Memorandum

To: Dave Merrill
From: Mike Nugent/Inspections Division Director
Date: 3/1/2005
Re: 133 Anderson St.

I have commenced the review of the remainder of the building plans and require the following information or have the following questions:

1 TYPICAL PENETRATION
SCALE: 6" = 1'-0"

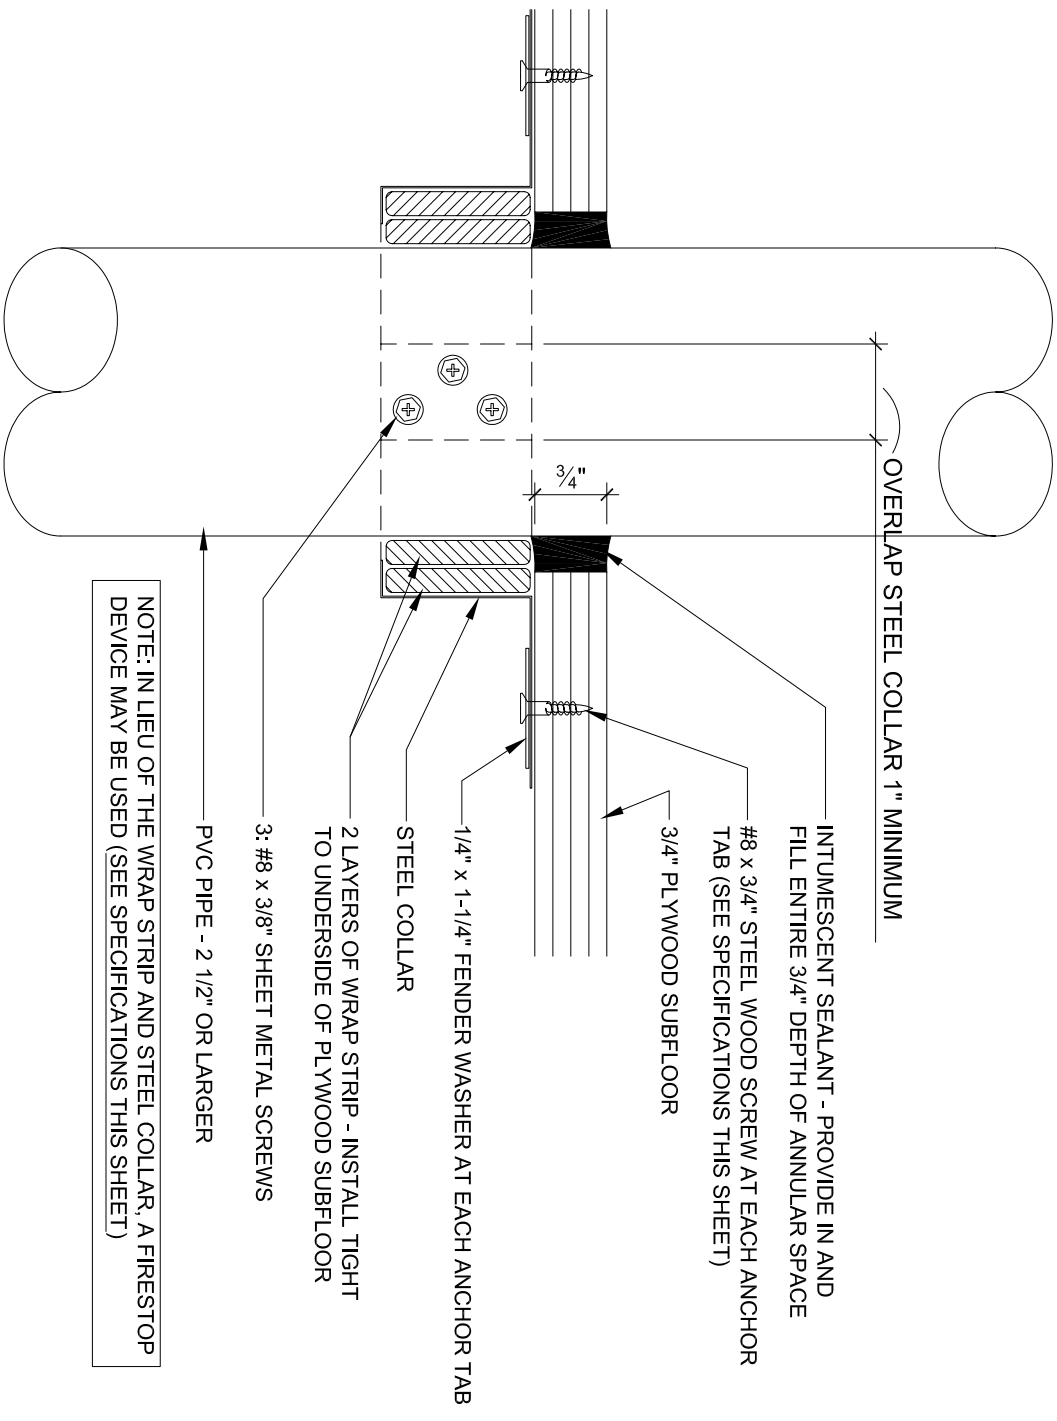
- 7) Does the shaft extend to the underside of the Roof?
- 8) Please provide a fire separation assembly penetration plans that includes bathroom vents, the dryer vents in the basement, all other penetrations that are not specified.

11 STAIR DETAIL
 A4-1 3/4" = 1'-0"

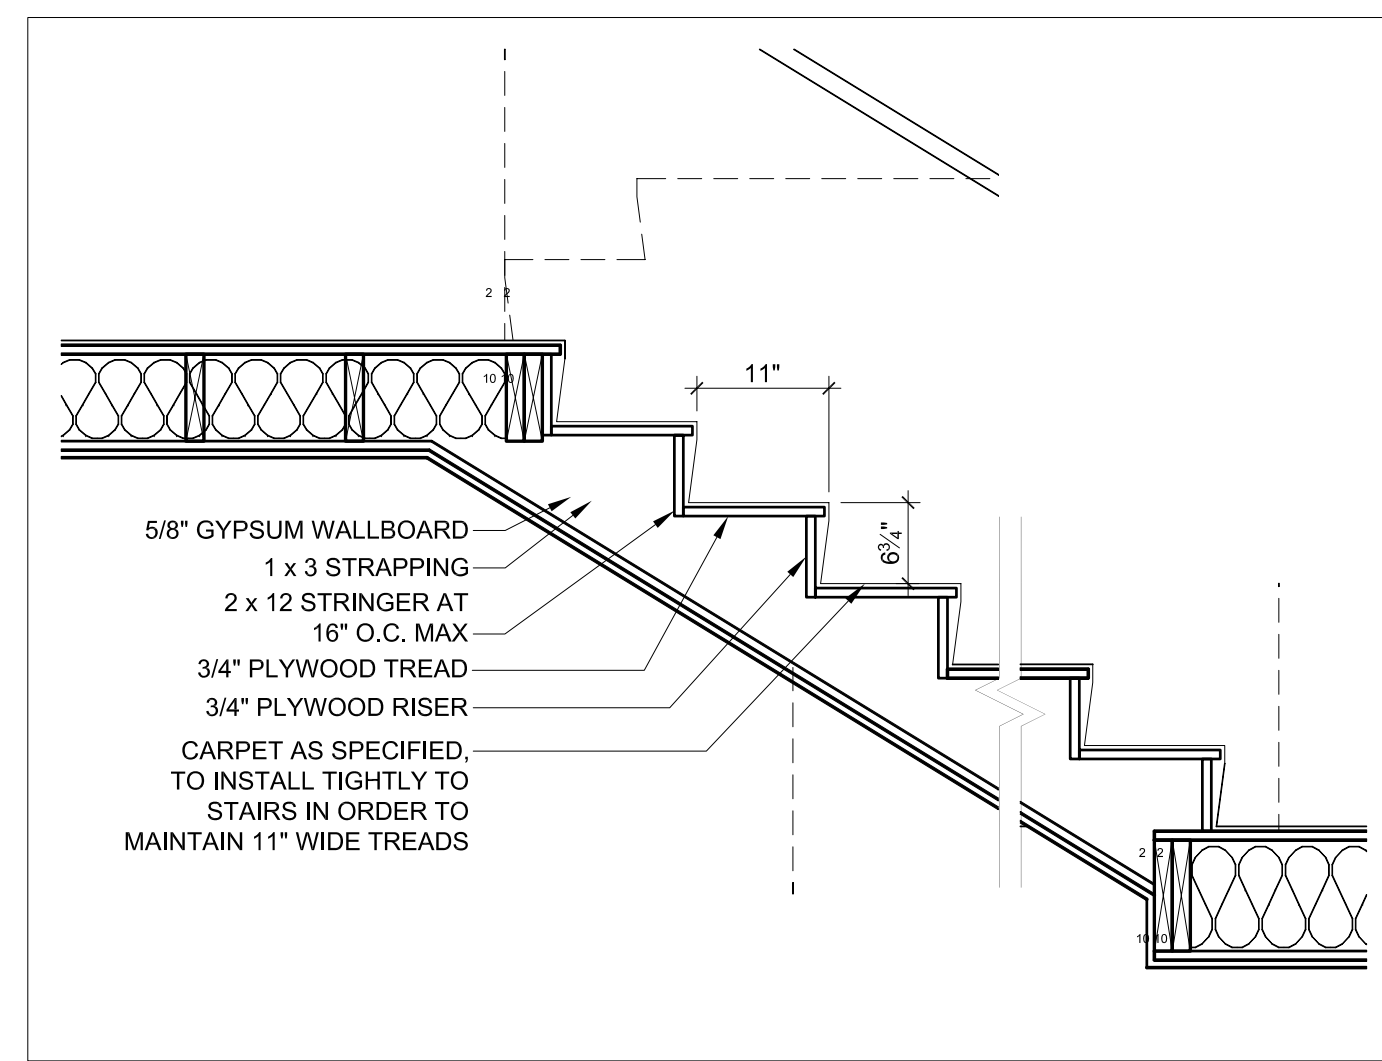
- 11) Please provide a stair cross section that shows tread and riser dimension and headroom.

A1.2

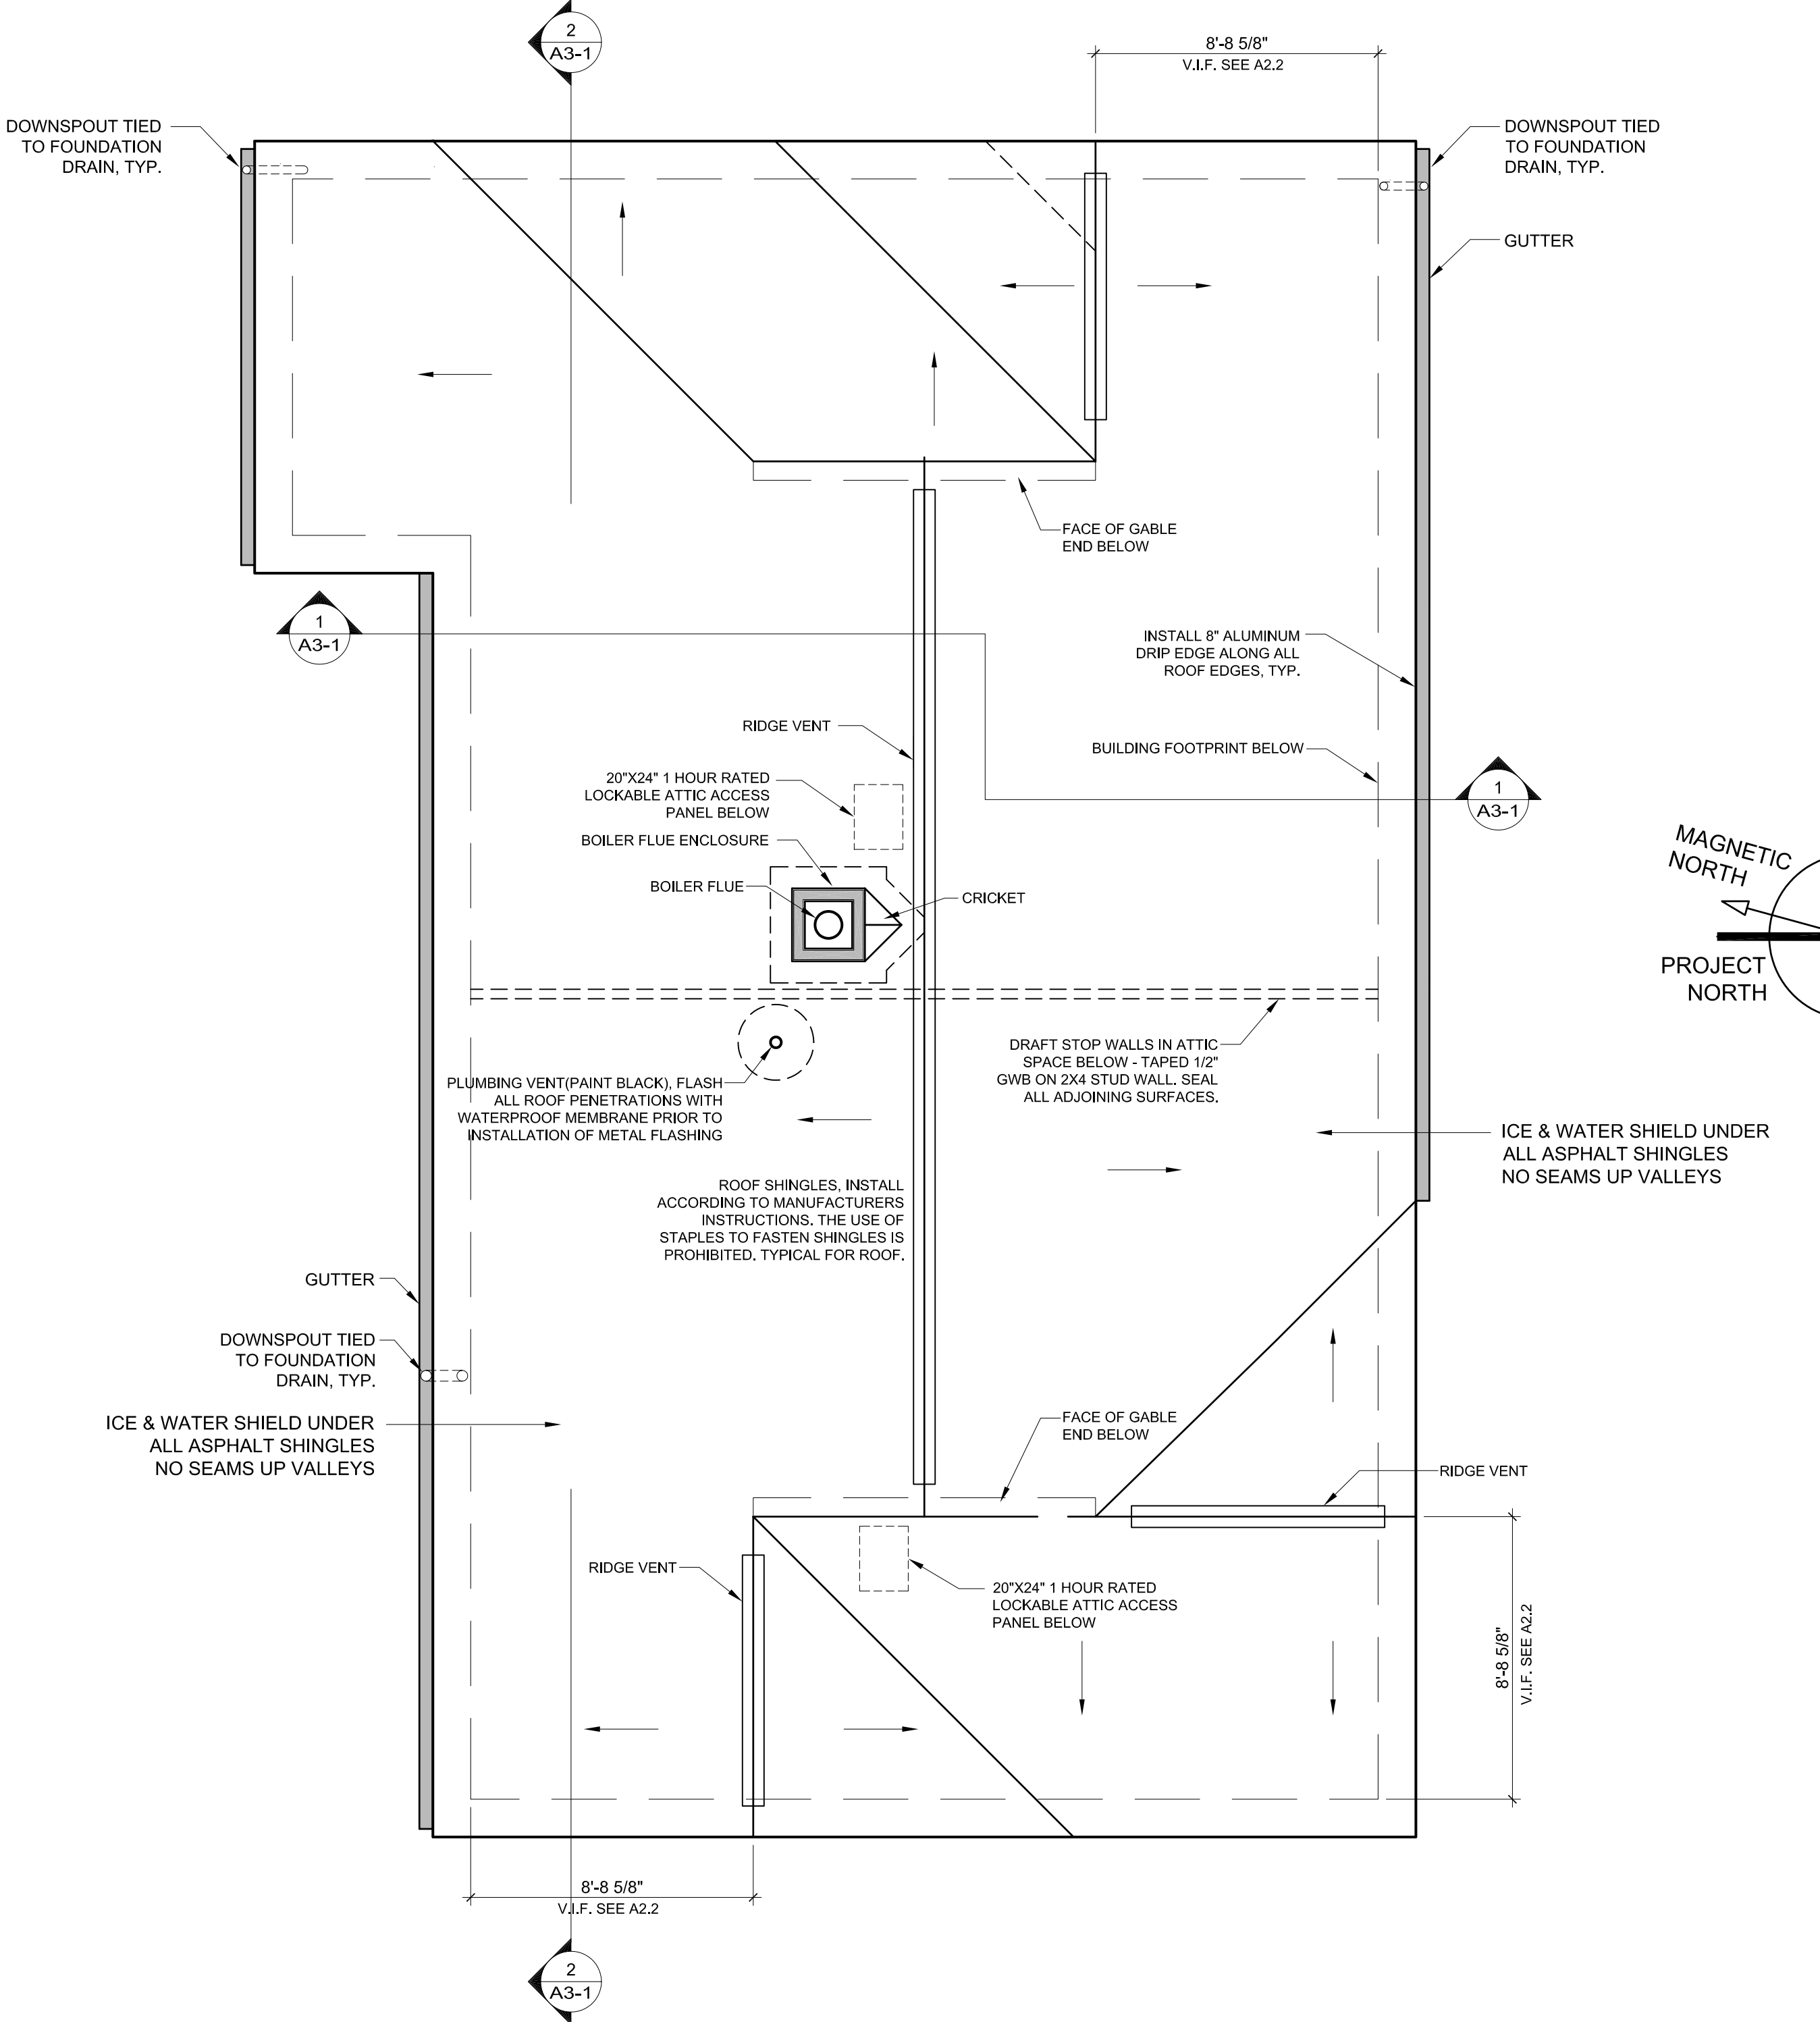
- 3) Please provide geotechnical info.
- 4) The fire separation distance of the south face of building 3 is 3 feet, there are no openings allowed on this wall, the plans show windows also please address how we can satisfy the parapet requirement .
